Subject: RE: 5 Cumberworth Road - 2025/62/90526 - Updated drawings and comments

It appears that the permission to remove the tree was granted after my original consultation. The tree has been granted removal due to it being made unsafe because of an excavator being used within the rooting zone. The council had no other option to grant the removal for safety reasons. Due to this being a protected tree within a conservation area I would expect to see mitigation planting for the loss of these trees.

title Site plan as proposed & location plan
number 24107D-02-P03
scale 1:200 & 1:1250
size A1

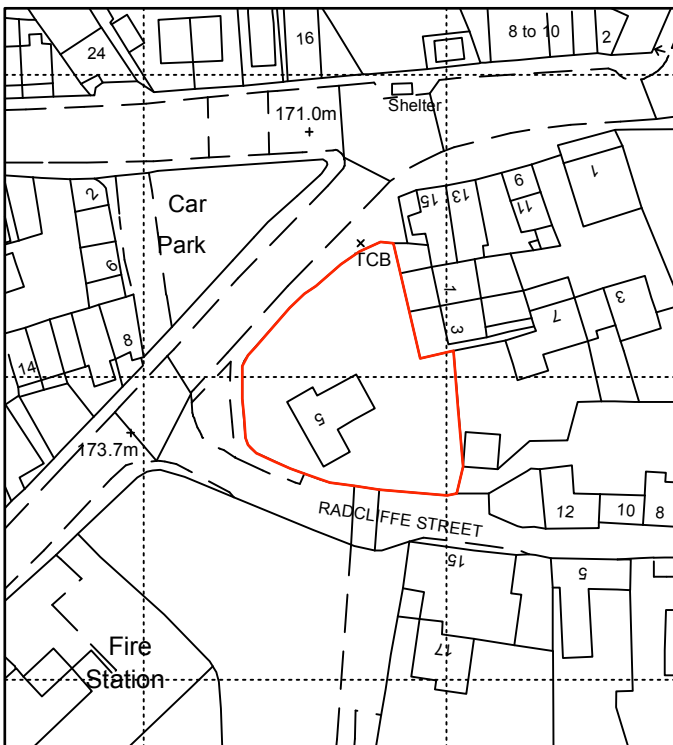
There is no longer the need for an Arboricultural impact assessment but there is now need for a landscaping plan showing the mitigation planting.
